10-31-24 CLARIFICATION:
PAGE: 1 OF 1
RE: UNNEEDED STUD
COLUMN REFERENCE
NUMBER.

FIRST FLOOR - ELEVATION 'D'

Wilson
Garage Left

S-2.1

FIRST FLOOR - ELEVATION 'D'
SCALE: 1/4" = 1'-0" ON 22x34, 1/8" = 1'-0" ON 11x17

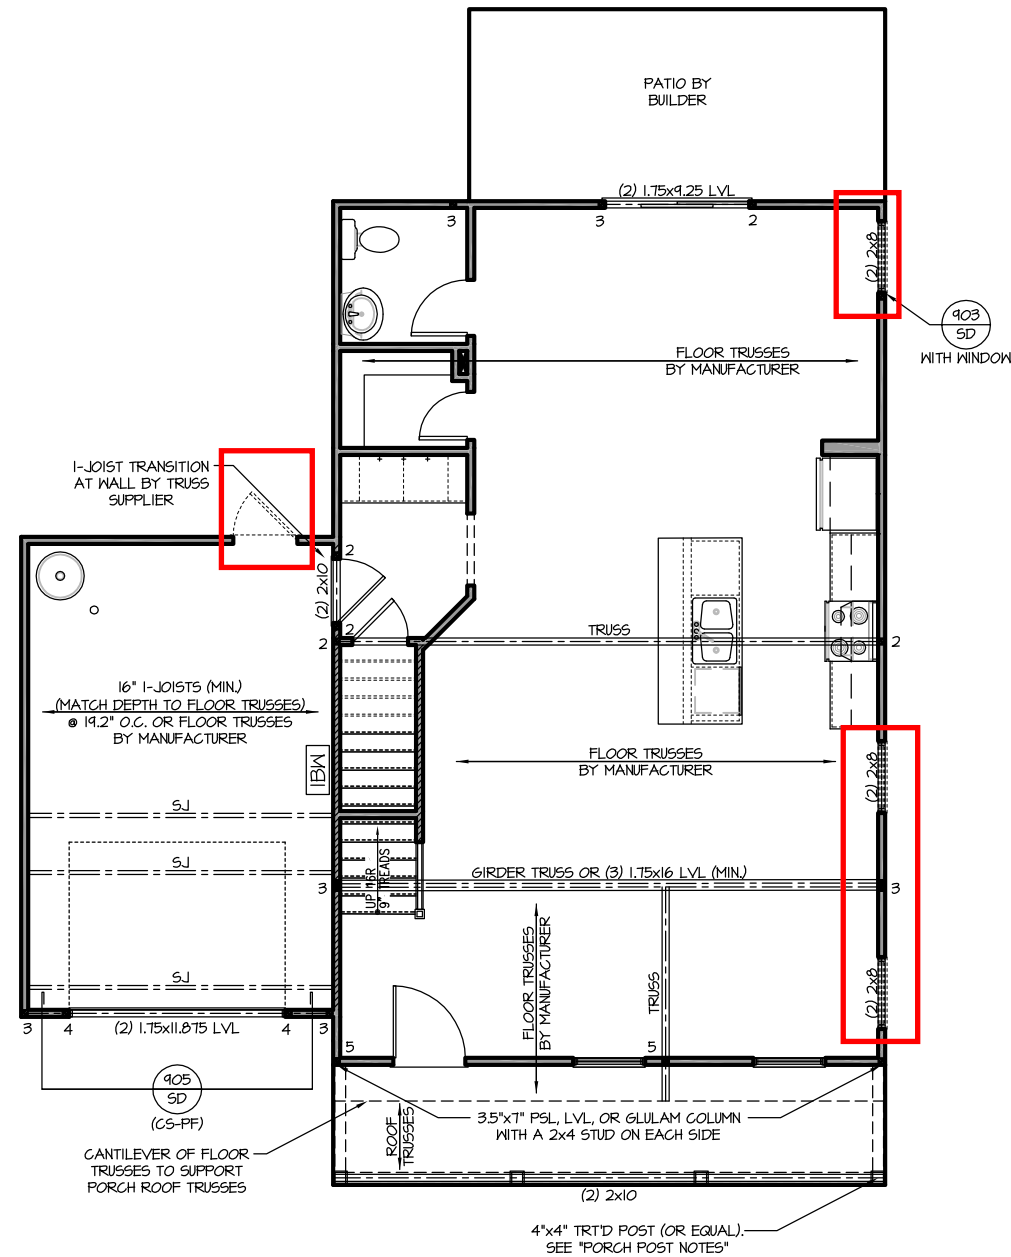
THE "5" IS MISTAKENLY
PLACED HERE AND IS
NOT NEEDED.
